Ref: 6/2018/2225/LB  
Date: 12/11/2018

## HISTORIC BUILDINGS AND CONSERVATION ADVICE

**RE: *Oshwal Centre, Coopers Lane Road, Northaw, Potters Bar, EN6 4DG***

PROPOSED FIRST FLOOR PLAN

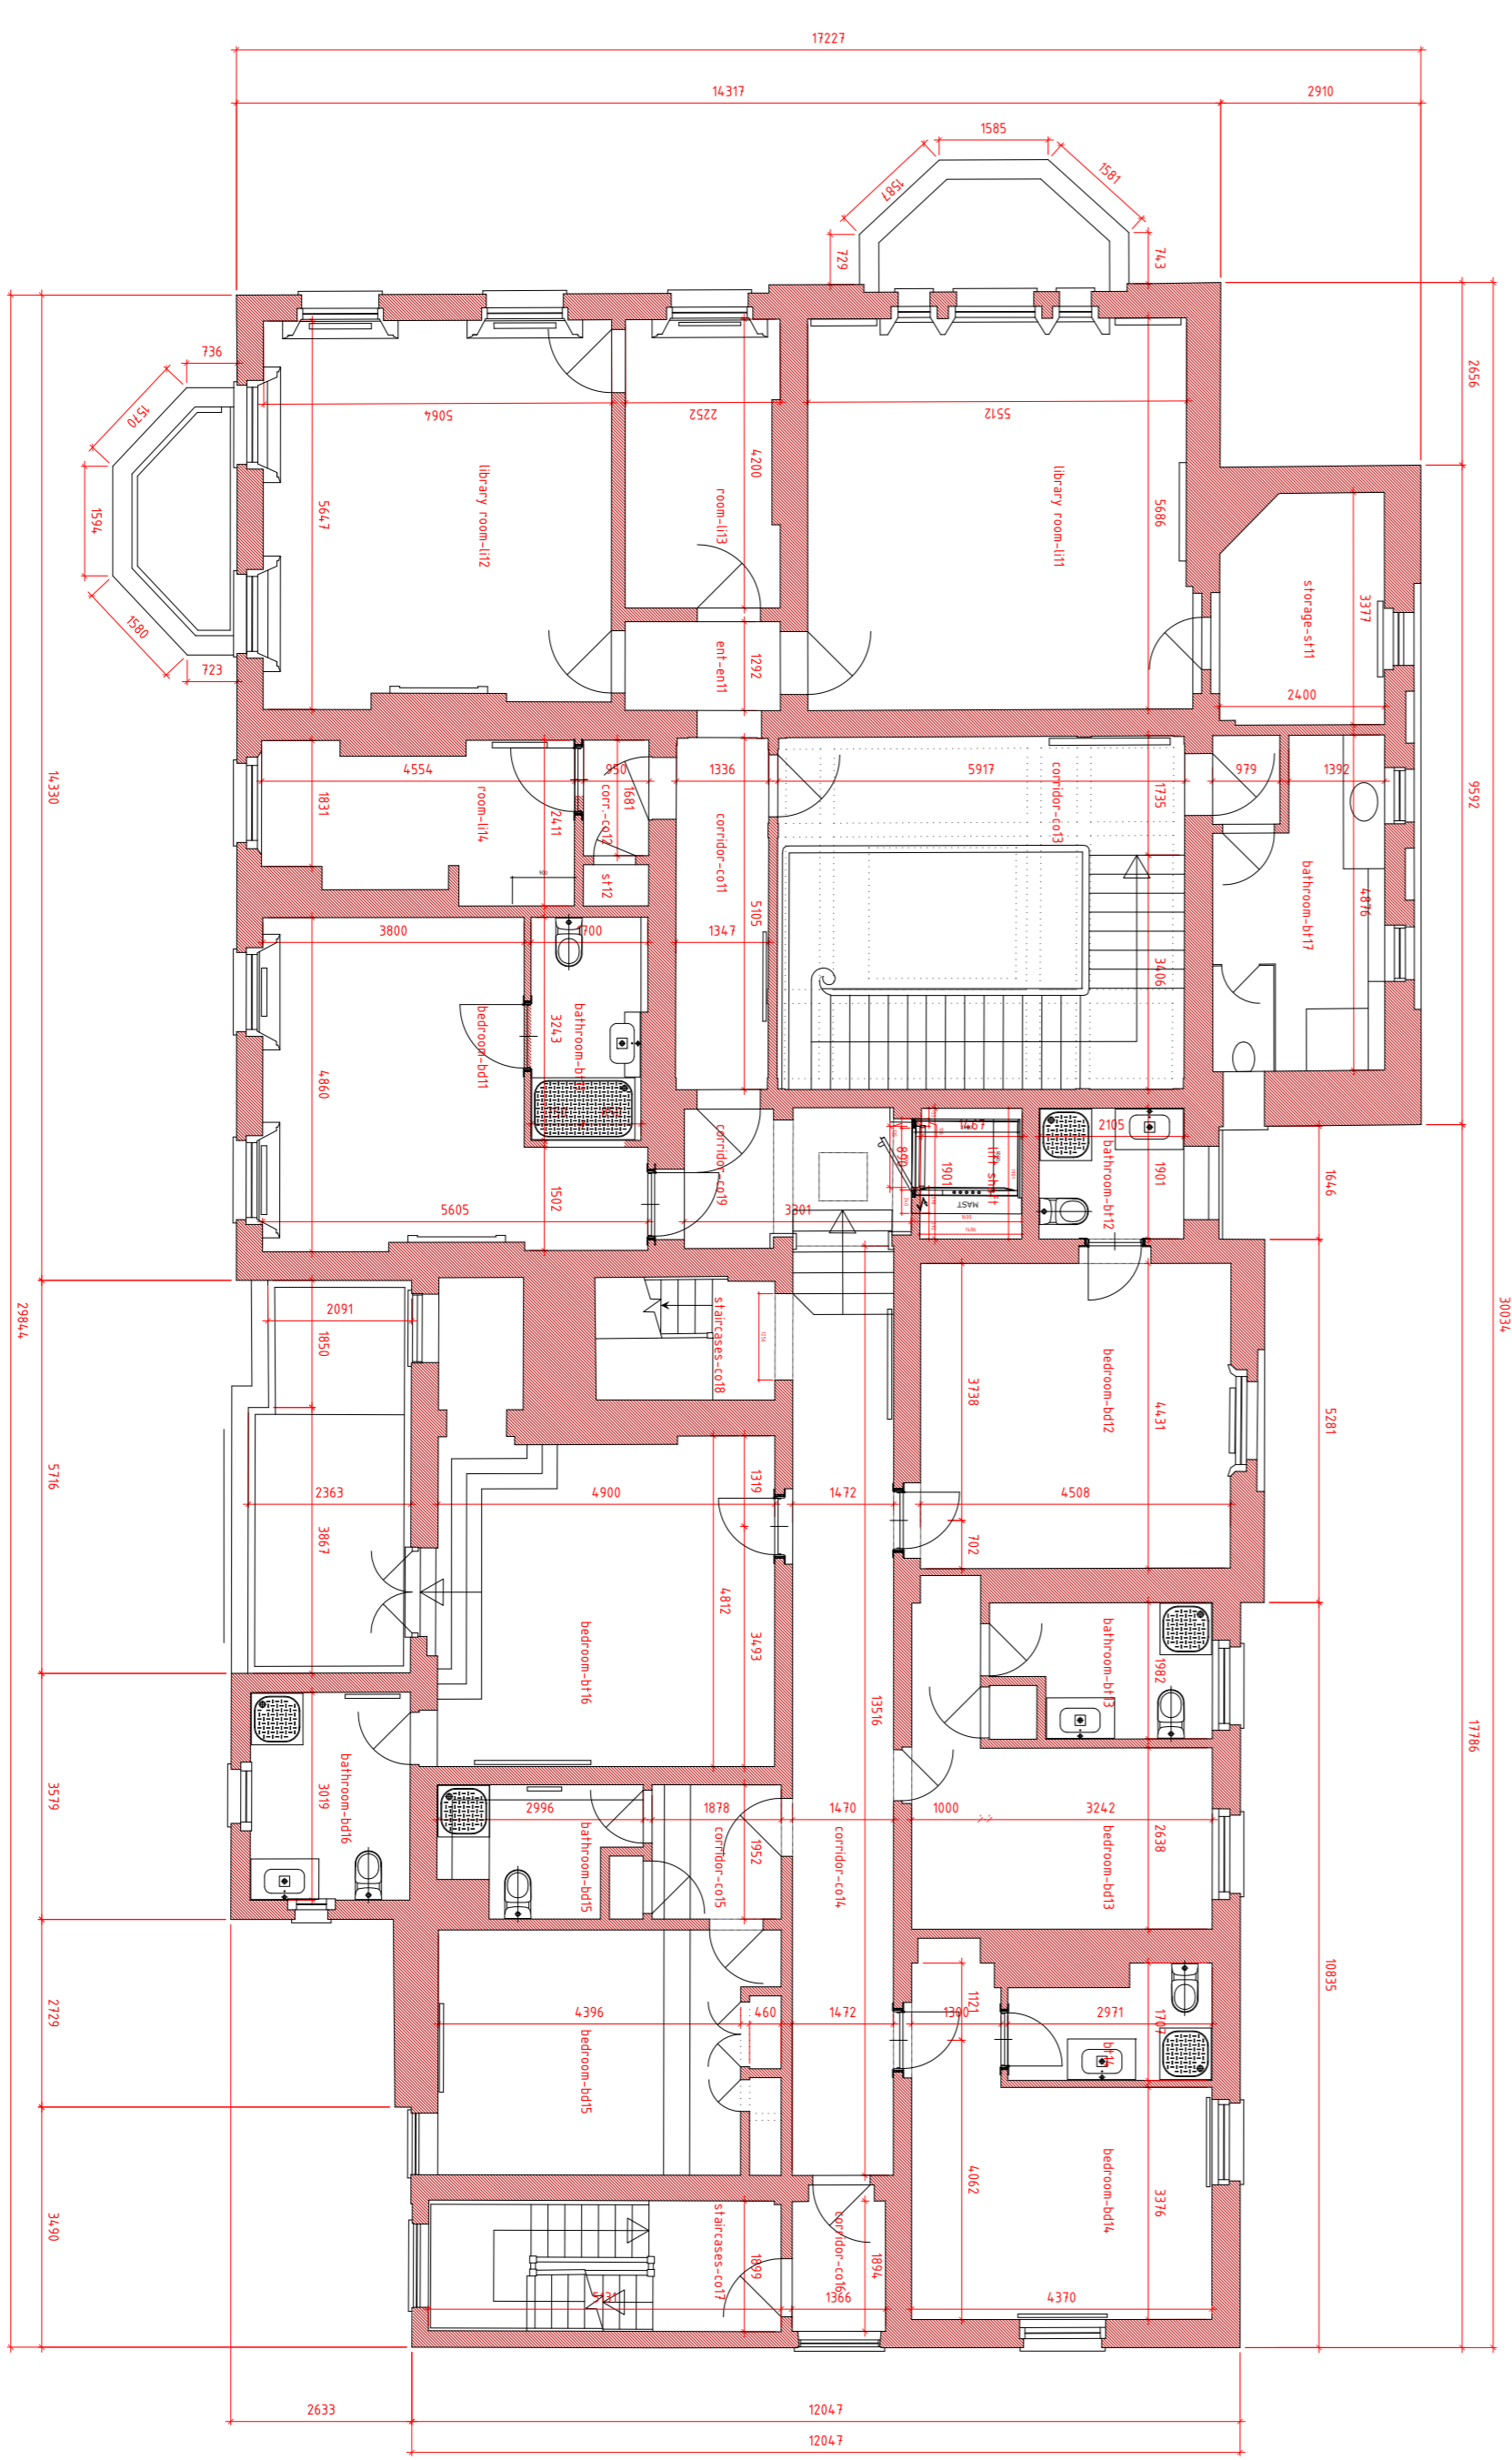
The proposed alterations are considered to be acceptable as they do not cause undue harm to the overall significance of the listed building. The highest degree of change is confined to the later 19<sup>th</sup> century section of the house on the first floor, predominantly in areas where alterations and additions have already been made in the mid-late 20<sup>th</sup> century. The most significant rooms on the ground floor (and their fixtures and fittings) remain unchanged and the first floor plan remains legible. The insertion of the ensuite 'pod' in room 28 curtails the volume of this original room. However, on balance, the proposed 'pod' is acceptable given the long-term use of the building, the reversibility of the intervention, and the glazing detail to the edges which provides a lighter touch and proposes to allow the original proportion of the room to be understood.

- Additional details of the junction between the new ensuite bathroom walls and existing walls in room 28, at a scale between 1:1 and 1:20 as appropriate, shall be submitted to and approved in writing by the Local Planning Authority before any works commence on the installation of the ensuite bathroom.
